Our ref: NE/2011/111405/01-L01
Your ref: N6/2010/3120/DC3
Date: 29 March 2011

Splashlands, Stanborough Road, Welwyn Garden City.

Redevelopment of site to provide a wet play area, adventure play areas, an educational play area, high ropes attraction, changing huts, education room, cafe and toilet facilities.

VIEWING PLATFORM PLAN
SCALE - 1:50

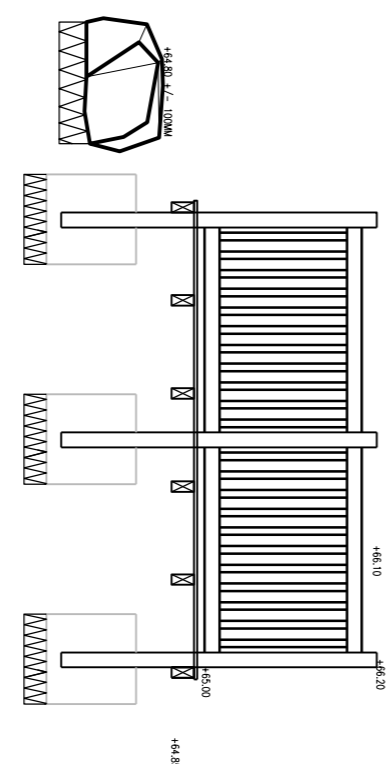
1. Provide sufficient information to demonstrate that the flood plain compensation scheme will ensure that there is no increase in flood risk as a result of this development.
2. Demonstrate that Sustainable Drainage Systems have been maximised for surface water attenuation.
3. No information has been provided about the timber viewing decks and other riverside features.

All works within 8 metres of the River Lee require Flood Defence Consent irrespective of planning permission granted. To ensure that the riverside features

are acceptable we will need to see further detail which demonstrates that there is no adverse impact upon river flows or biodiversity. Please contact Sarah Smith on 017007 632629 to discuss this further.
